PMcL/3167D5/SA1 Response

**NEW ROAD DEVELOPMENT
A259 NEW ROAD, RUSTINGTON,
LITTLEHAMPTON**

S278 HIGHWAY ACCESS WORKS

**Road Safety Audit Designer's Response
STAGE 1**

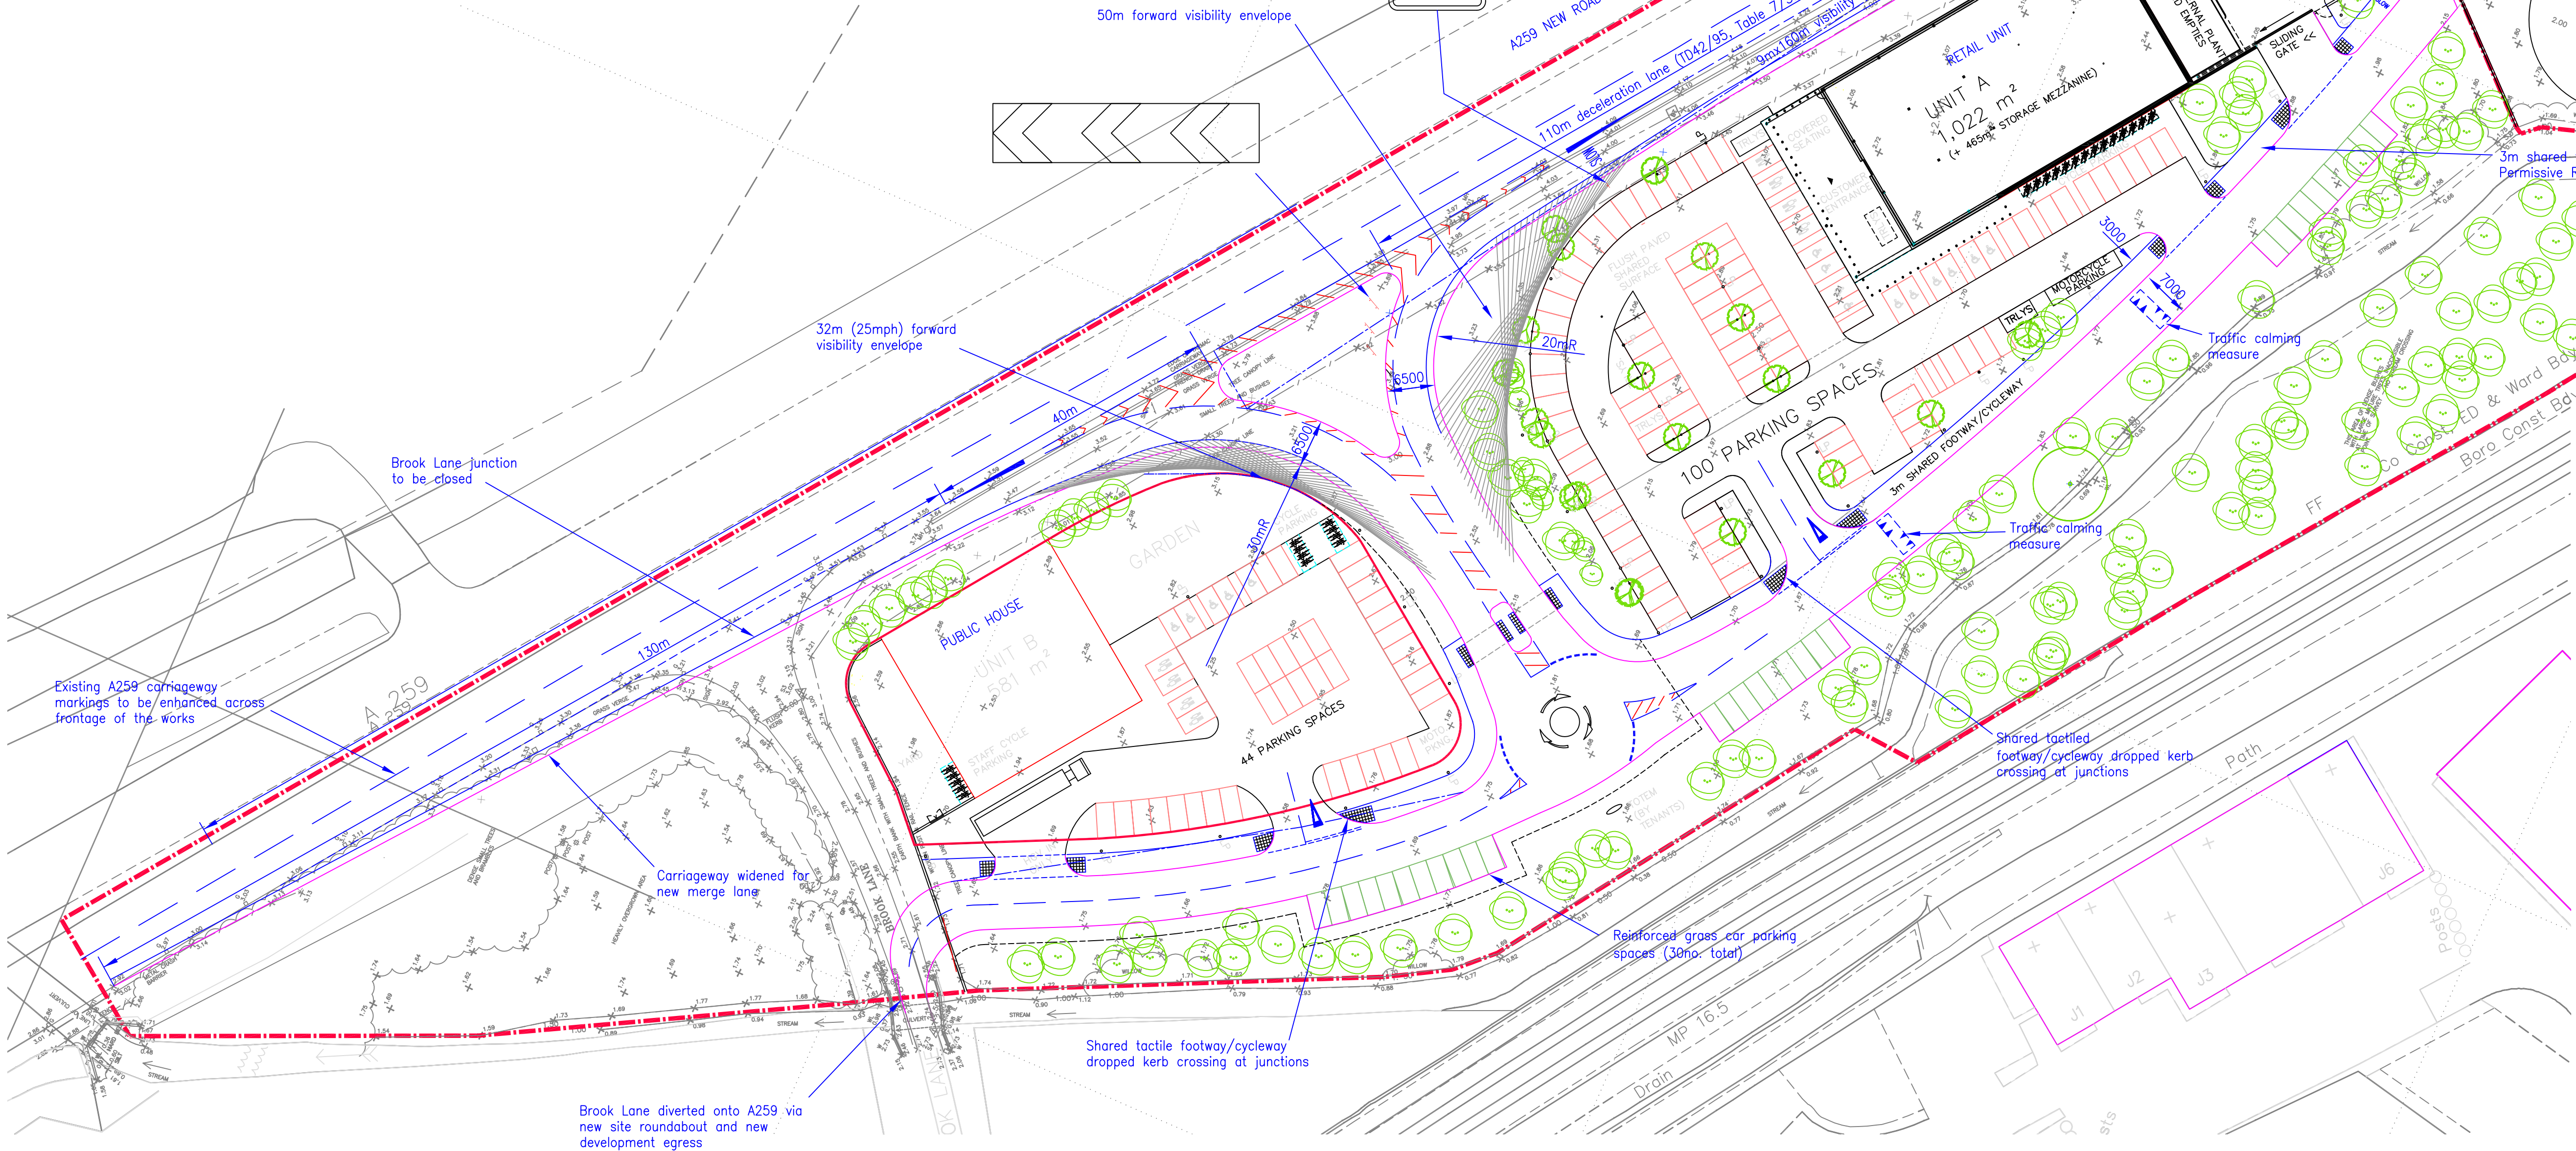
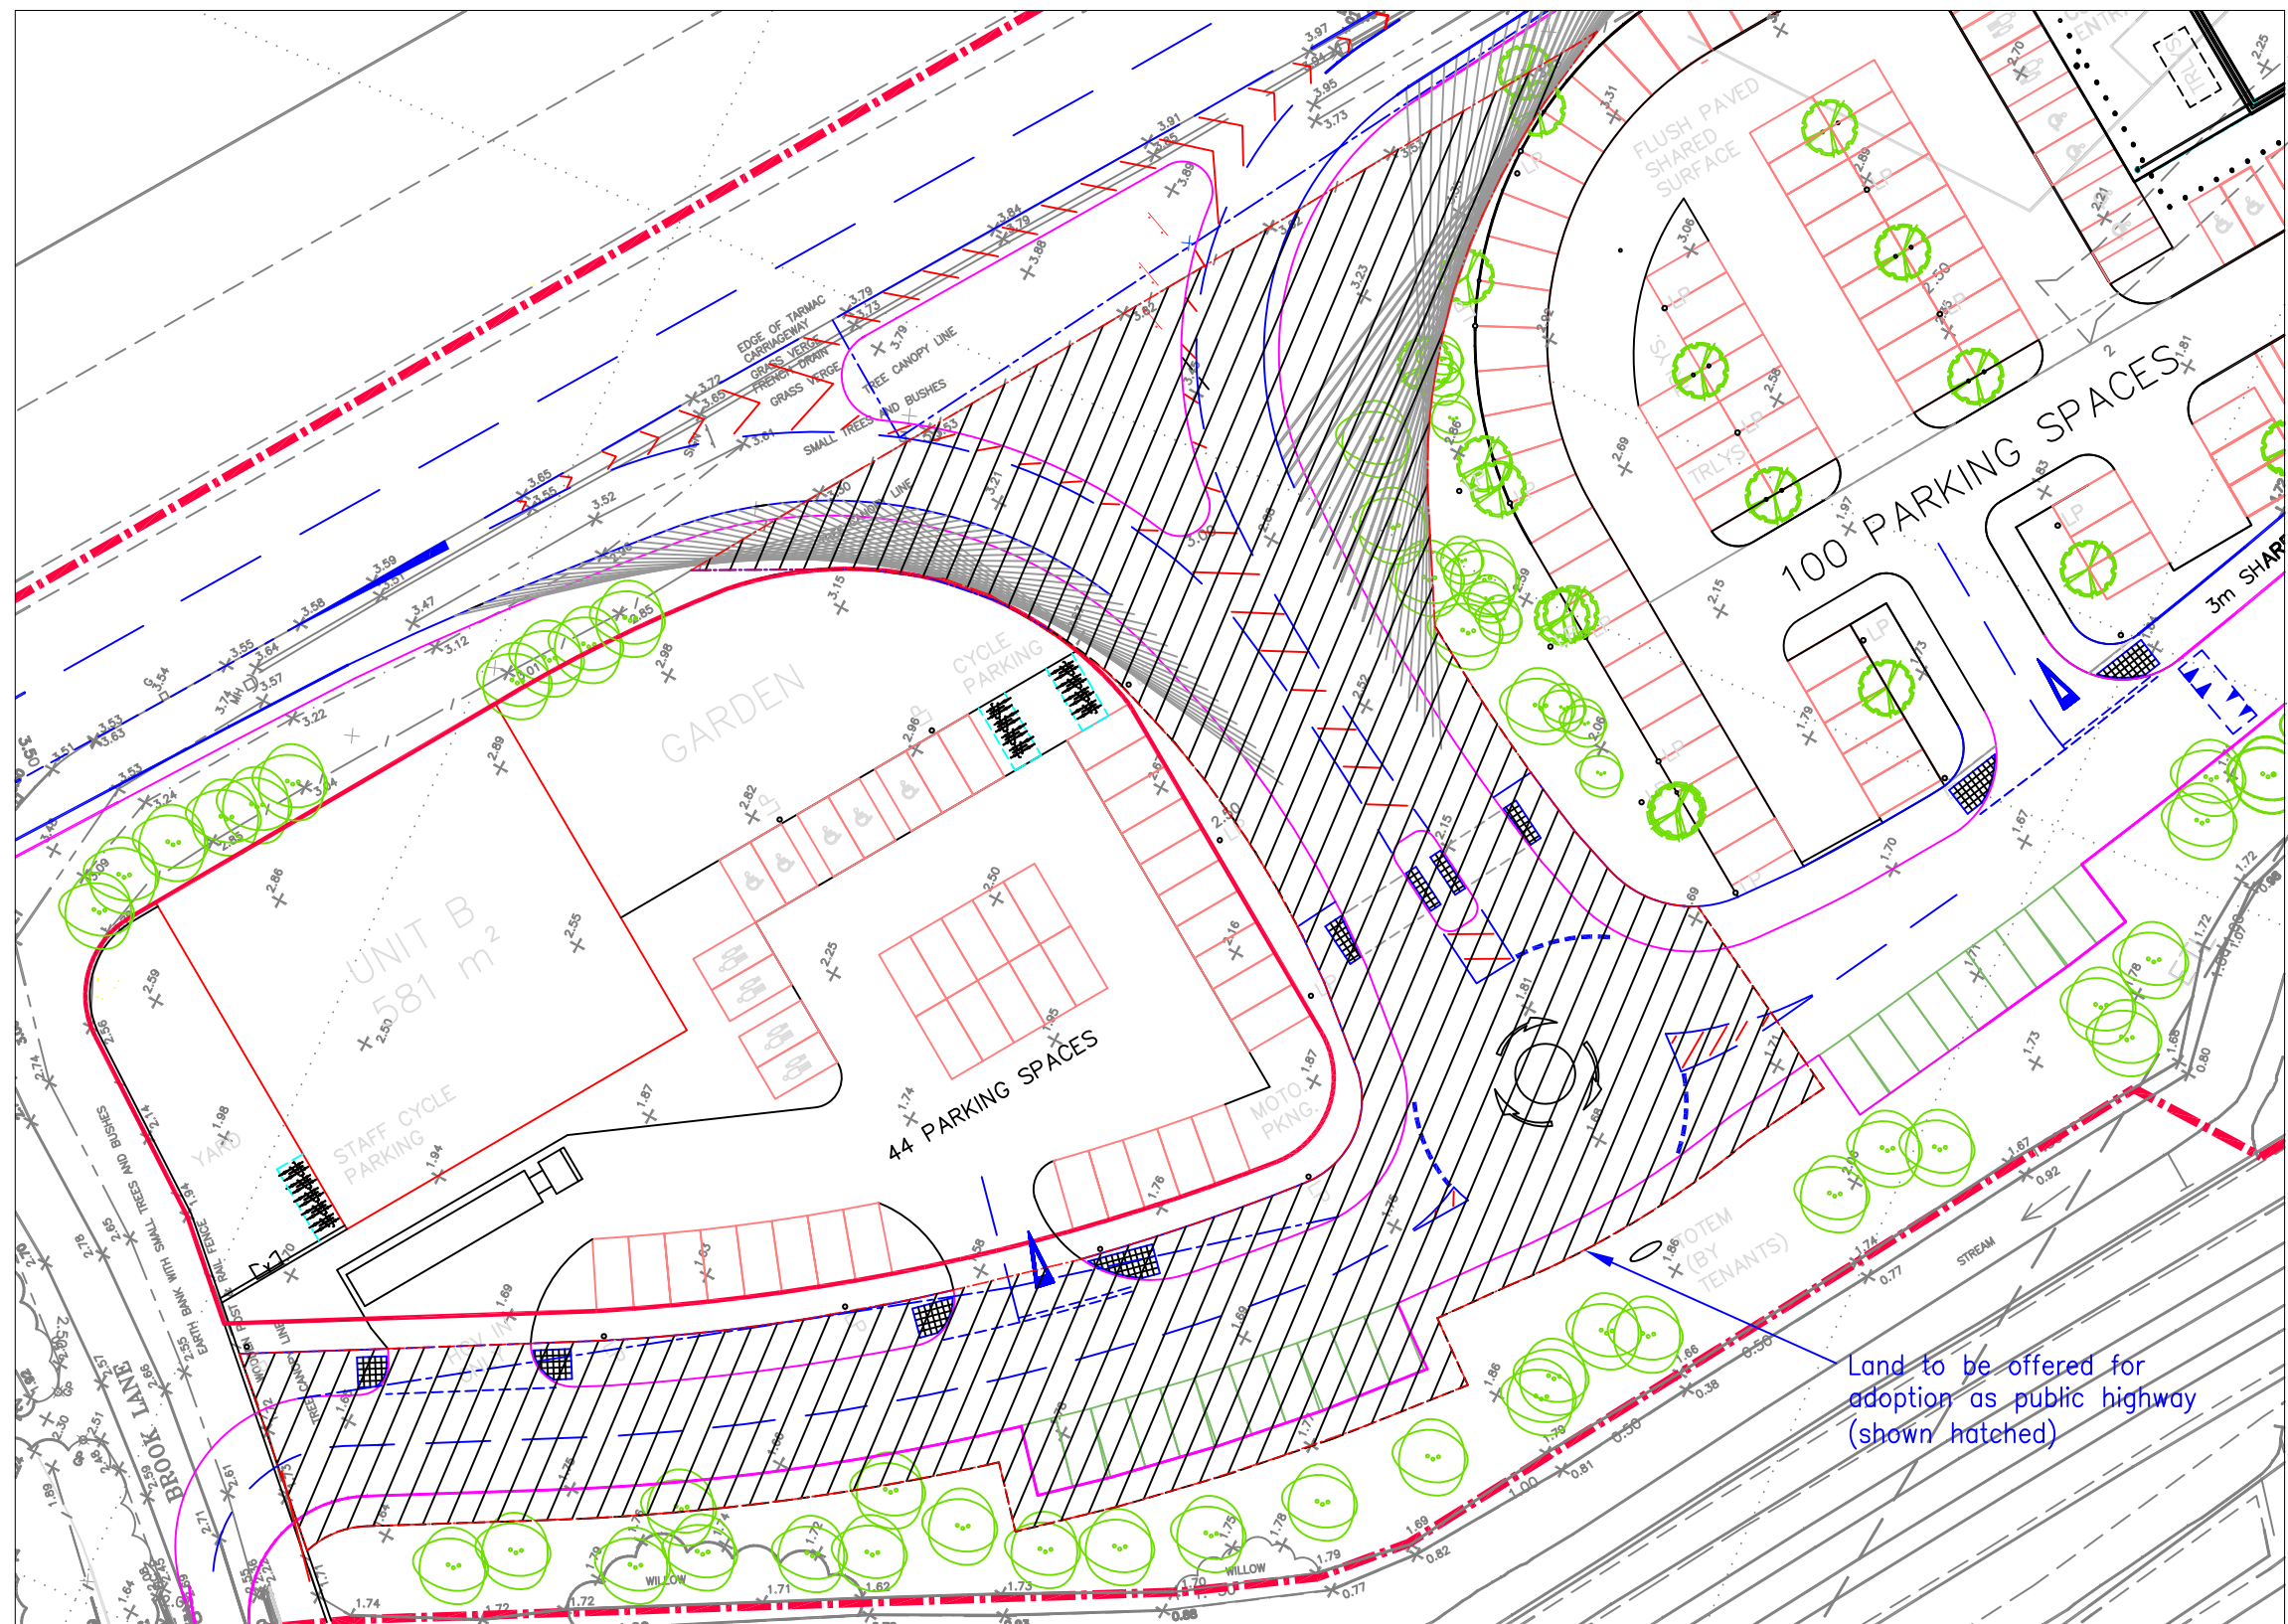
Problem - No dropped kerb crossing points

The scheme drawings do not identify any directional road signage and therefore it is possible that vehicles intending to access the proposed retail unit and public house, will manoeuvre as if to access the adjacent recently constructed development and change direction at the last minute when the driver becomes aware of the access to the proposed retail unit. Last minute lane changes could result in vehicle.

The A259 road markings alongside the proposed footway / cycleway appear to be faded. This is an existing issue, however observations show that the recently constructed scheme has re-laid markings adjacent to the works. There will therefore be a gap in the markings which could confuse drivers

Recommendation: It is recommended that the A259 road markings are re-laid alongside the entire scheme.

Problem – No directional signage proposed

The scheme drawings do not identify any directional road signage and therefore it is possible that vehicles intending to access the proposed retail unit and public house, will manoeuvre as if to access the adjacent recently constructed development and change direction at the last minute when the driver becomes aware of the access to the proposed retail unit. Last minute lane changes could result in vehicle.

Recommendation: It is recommended that appropriate signage is installed to inform approaching drivers of the amenities off each access.

RESPONSE: Shared tactile paved pedestrian/cycleway dropped kerb crossings have been added to **Drawing No. REDW-3167-131**.

RESPONSE: A note has been added to **Drawing No. REDW-3167-131** to confirm that existing A259 road markings along frontage of the new highway works shall be refreshed as part of the detailed design.

RESPONSE: A combined advance direction sign (ADS) for both accesses will be included in the detailed design which will identify the presence of 2 accesses and their respective uses. The proposed signage will be located to the east of the adjacent development. Note 4 has been added to **Drawing No. REDW-3167-131**.
